RE: SSD-82548708 Residential Flat Building with Infill - Affordable Housing-24,26 &28 Middle Harbour Rd Lindfield – 94 Apartments

Please find accompanying the reasons for my objection to this MHR Lindfield Investments Pty Ltd residential development. In addition to this being an inappropriate development for its location with major impacts on surrounding dwellings, there exist a number of inaccuracies in the Environment Impact Statement (EIS).

Drawing No. DA207 Revision 03

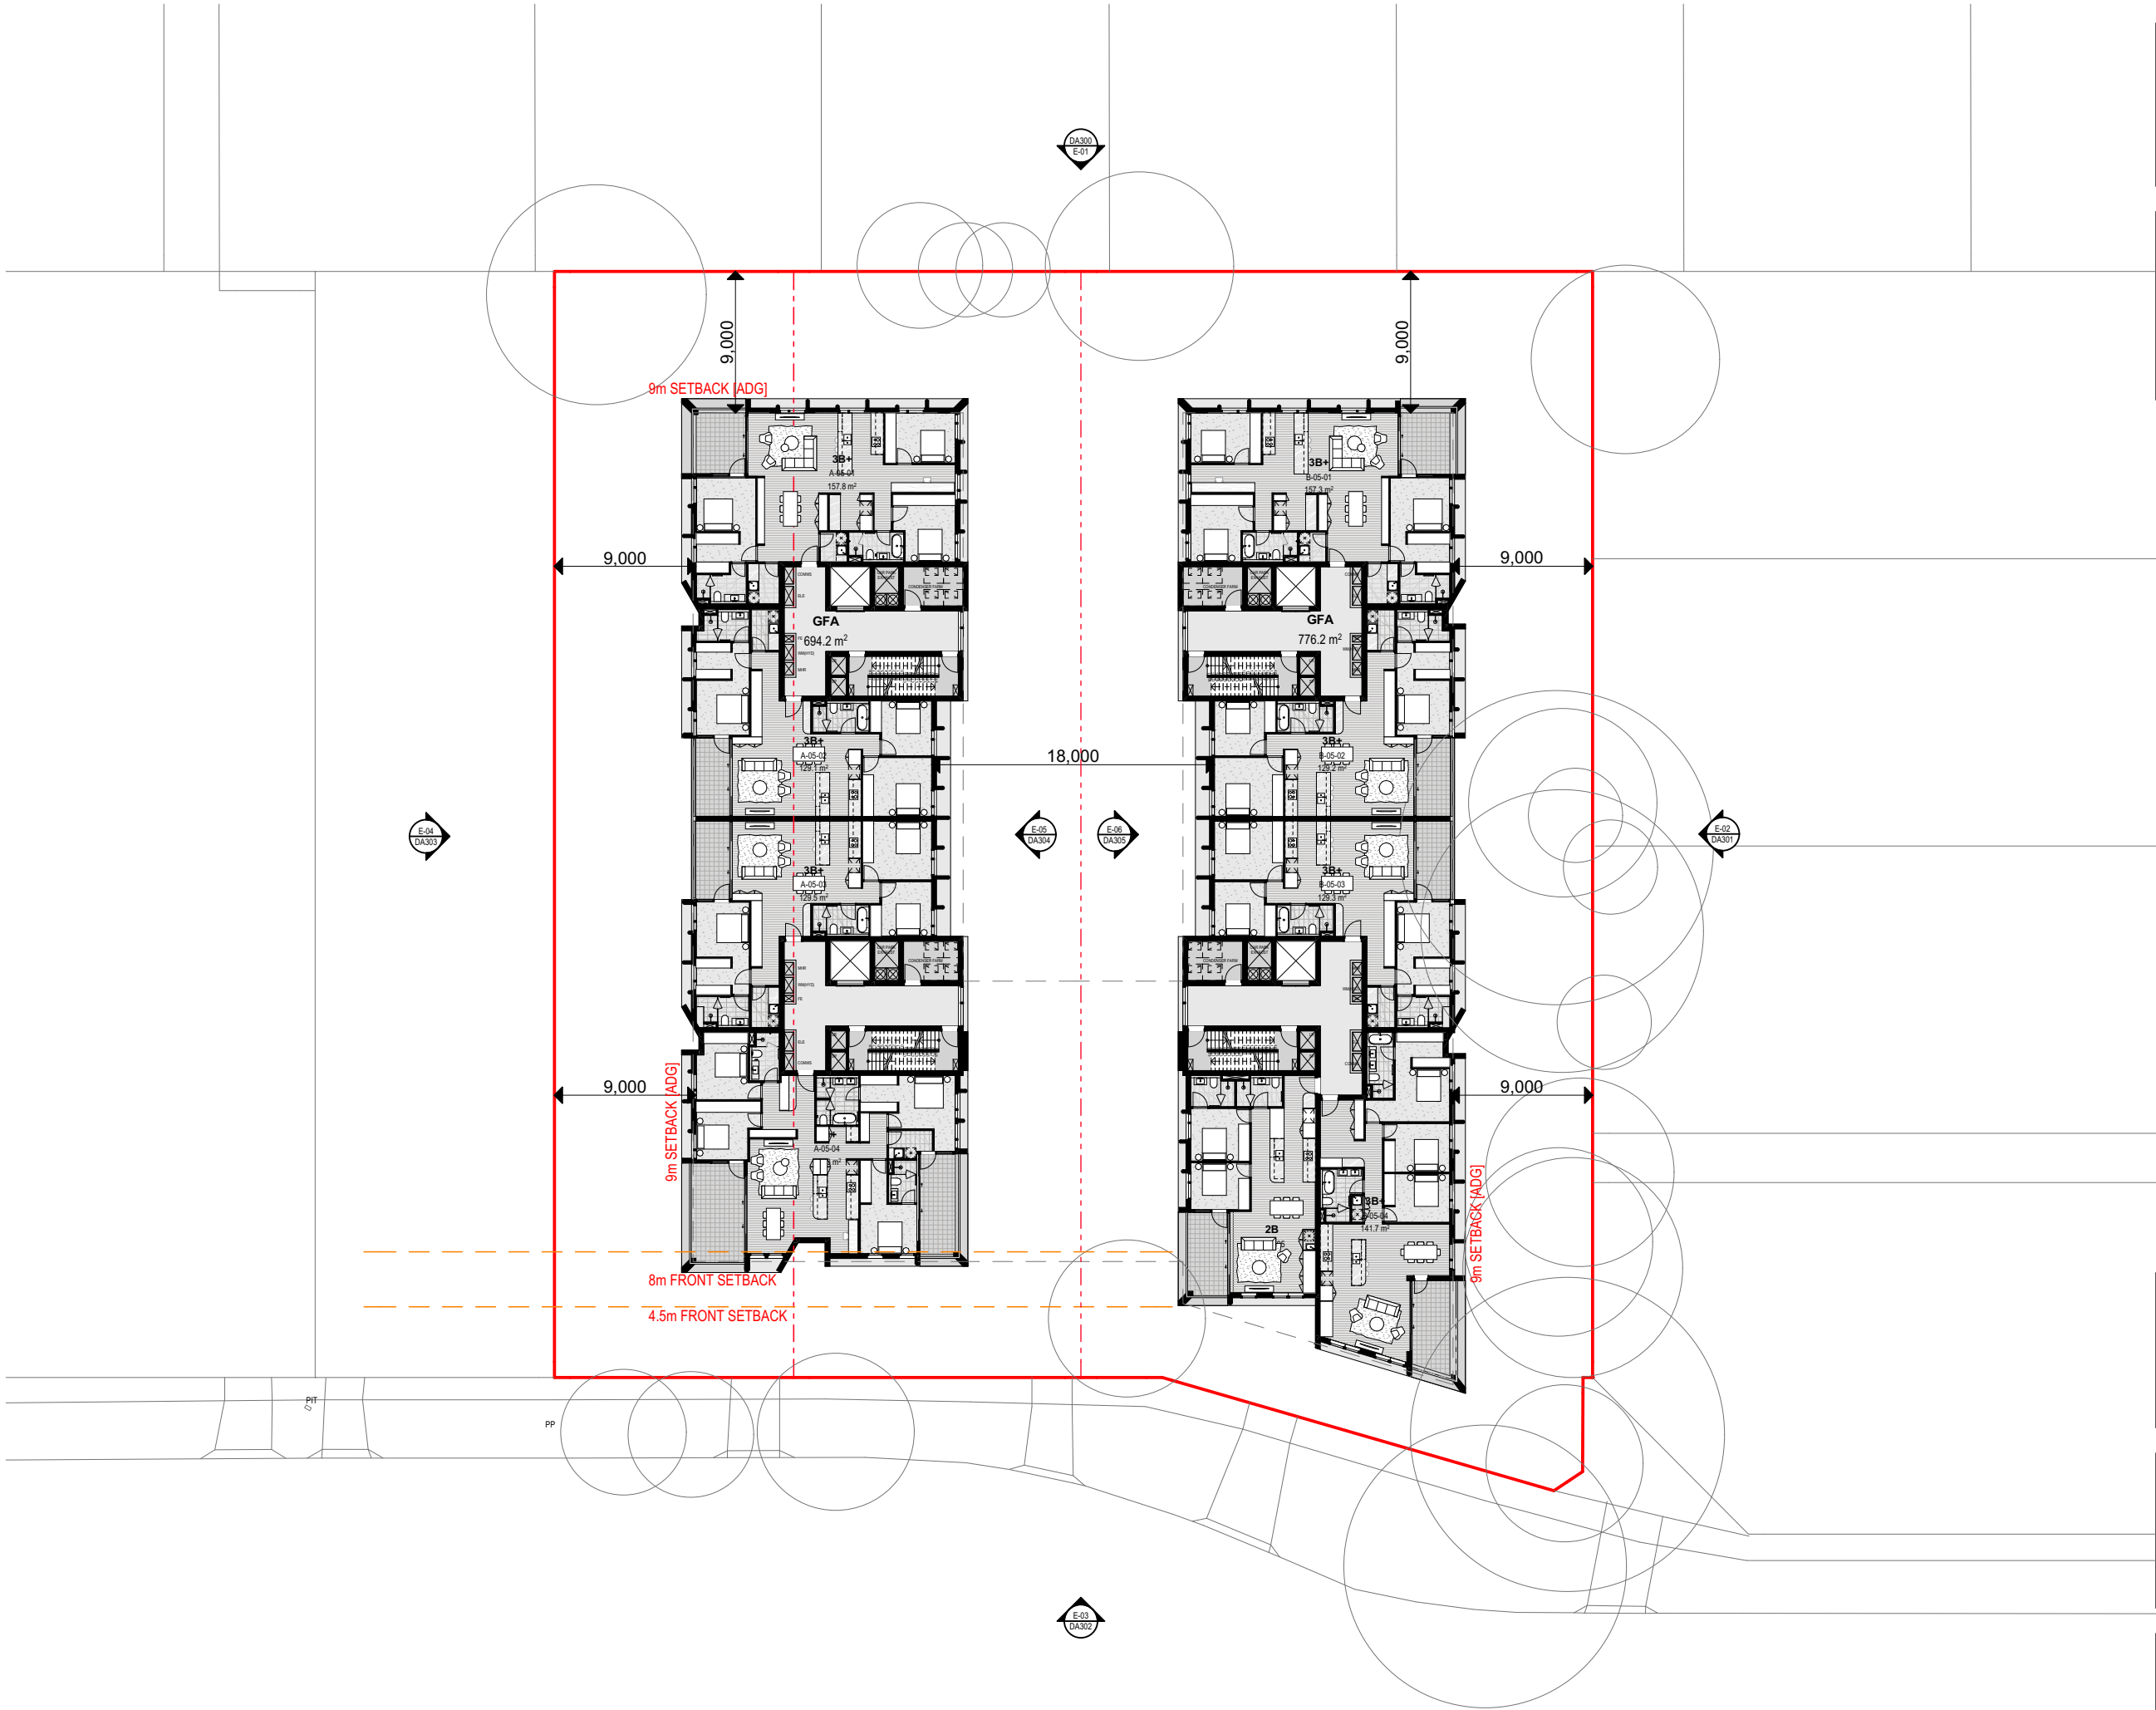
- For side and rear setback requirements to ensure deep soil, landscaping and tall trees are accommodated to all sides of the building: a minimum of 6m from the side boundary for all levels up to the fourth storey and a minimum of 9m to the fifth storey and above. A setback of 9m is required from the boundary to a lower density site. Again, not met.

- The proposal allows a 6m side and rear setback and then reduces this to a 2m setback on the western side and 3m on the eastern and northern side due to the encroachment of the floor terraces and courtyards at the ground level. This is another non-compliance issue. **This is not a minor infraction but a 66% reduction!**

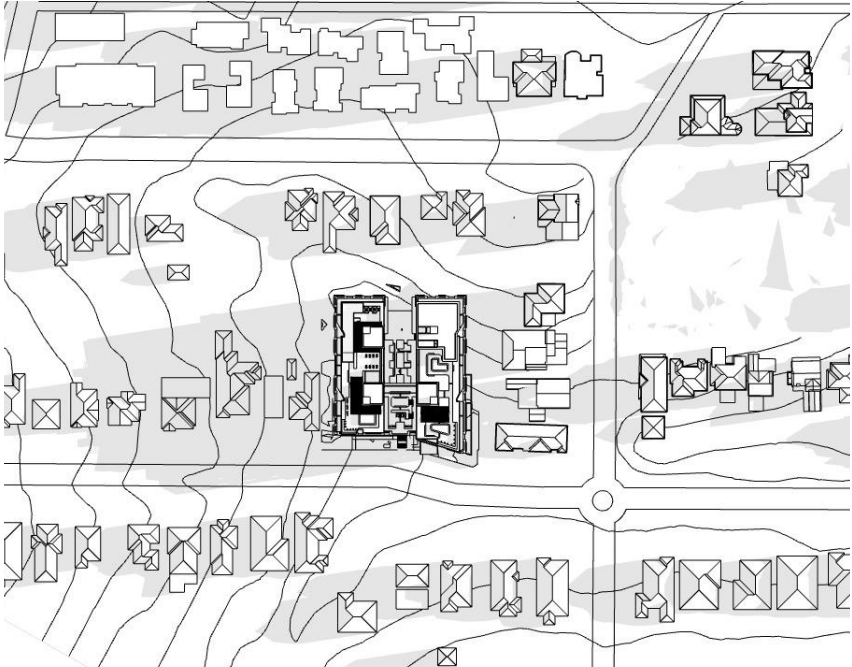
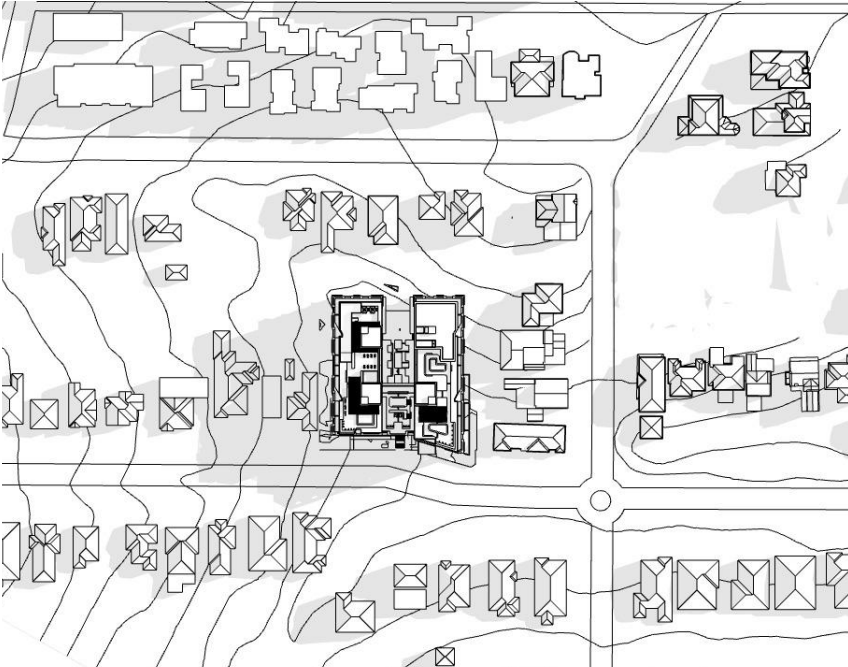
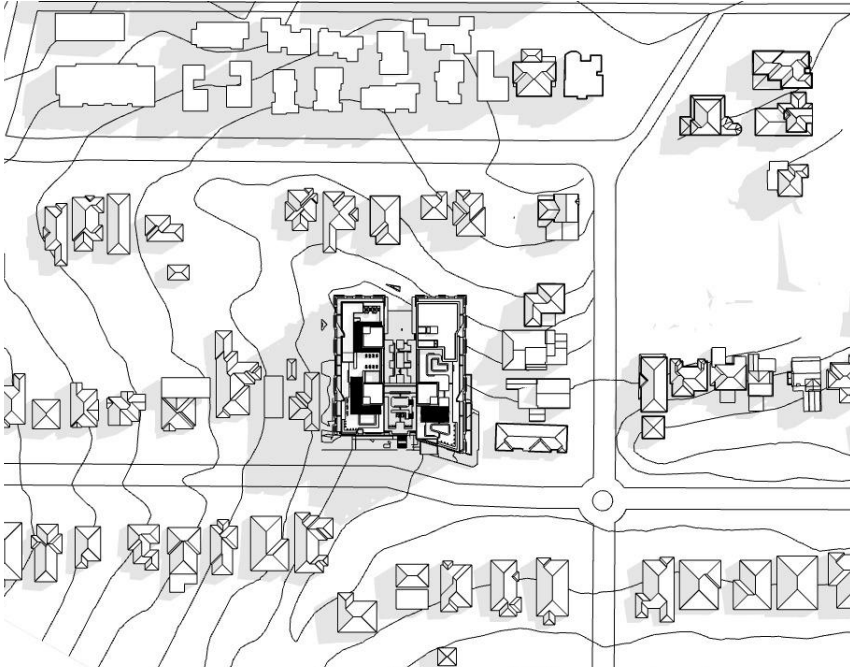
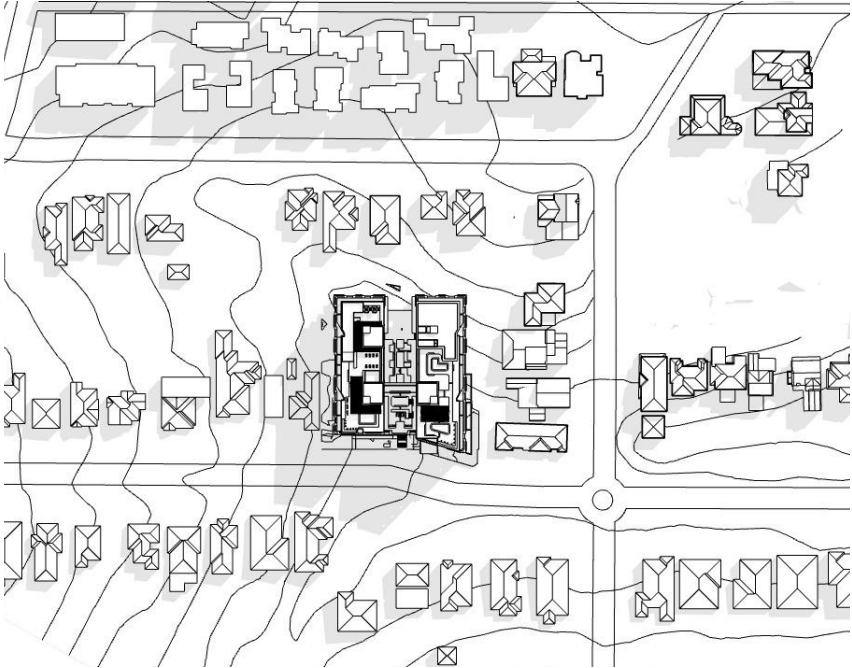
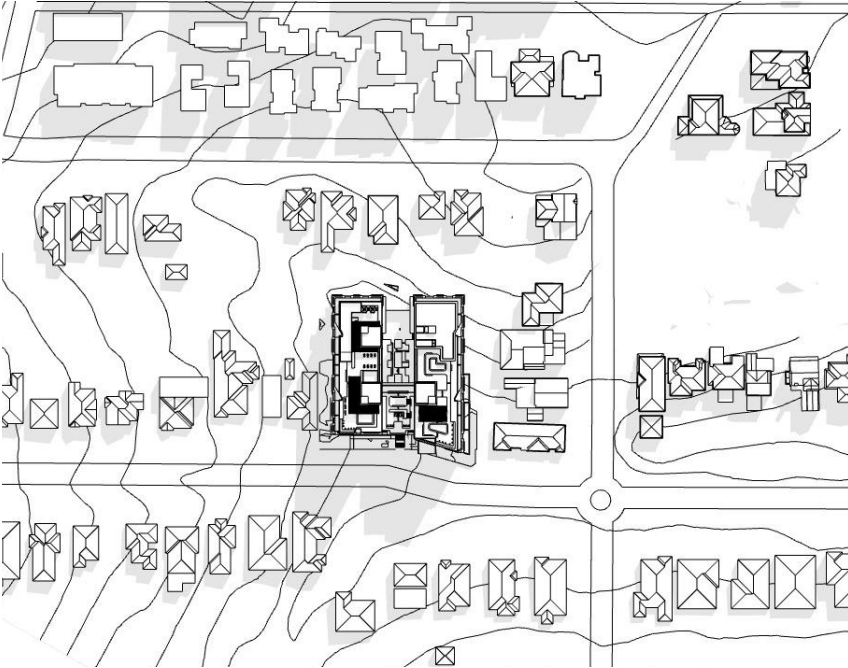
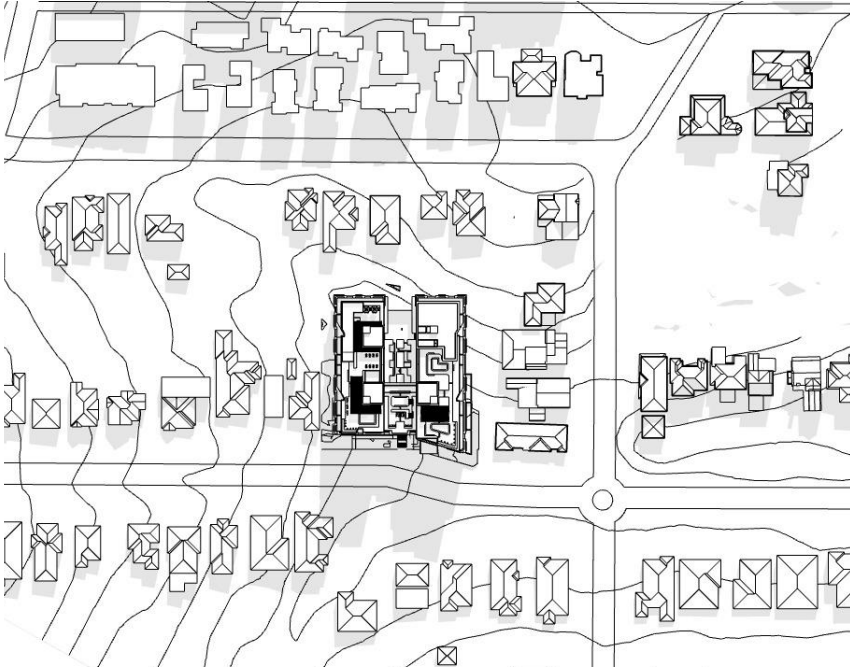
- Direct sunlight into western properties is severely diminished in winter, with number 22 Middle Harbour Rd unlikely to receive any direct sunlight into its living areas at this time.

- Stipulated in the ADG is that living spaces receive at least 2 hours of sunlight. This must also apply to the existing residences west of this massive development.

- The EIS report is clearly in error in stating that the loss of sunlight to these residences is minor. The EIS cannot meet the requirement for 2 hours of sunlight for internal living spaces, it can only state 2 hours 'of solar access to their outdoor amenity spaces' in midwinter. This development ensures dark and damp neighbouring residences where previously there was sunlight.
